COMMENTS: BM 7/7/2010

Spoke with Matt Low from H&H Const. & discussed 10 ft setback from any waterline. He will have the irrigation system marked & I will call Sara Scott & meet her on site on 7/8/2010 if possible.

Operation Permit

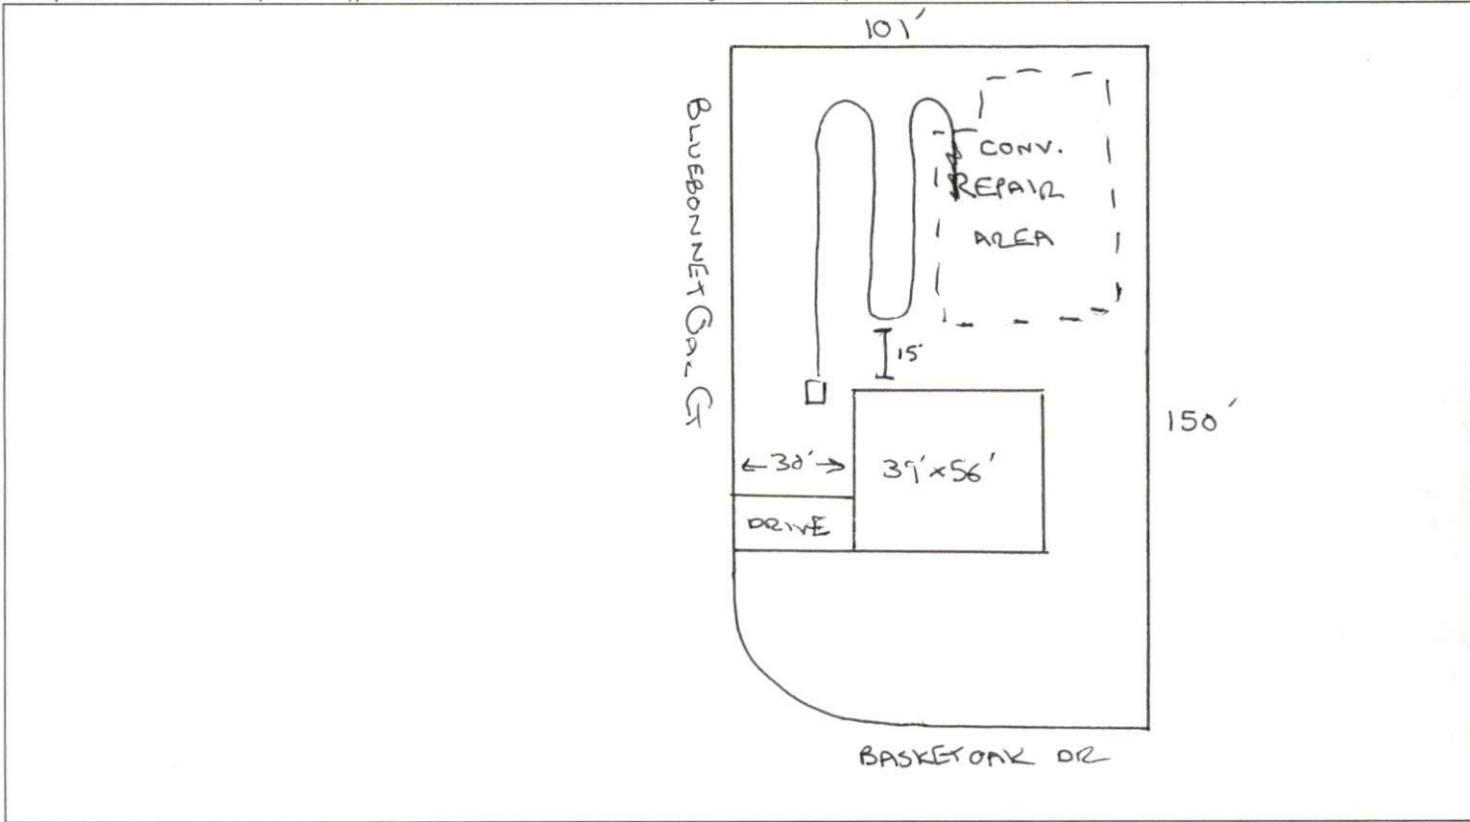
BM 7/9/2010 I spoke w/ Sara Scott about the irrigation system running over the septic tank & drain lines. She said that they would have it corrected & call me back. I then left her a message ~~later~~ later that she should have the septic contractor remove the irrigation over the drain lines so they could verify whether the system was damaged or not.

BM 7/14/2010 Made a site visit to lot 140 Forest Oaks. Tried to probe the area where the irrigation line was, it could not locate. It appears that the line had been removed & the required setbacks are now met.
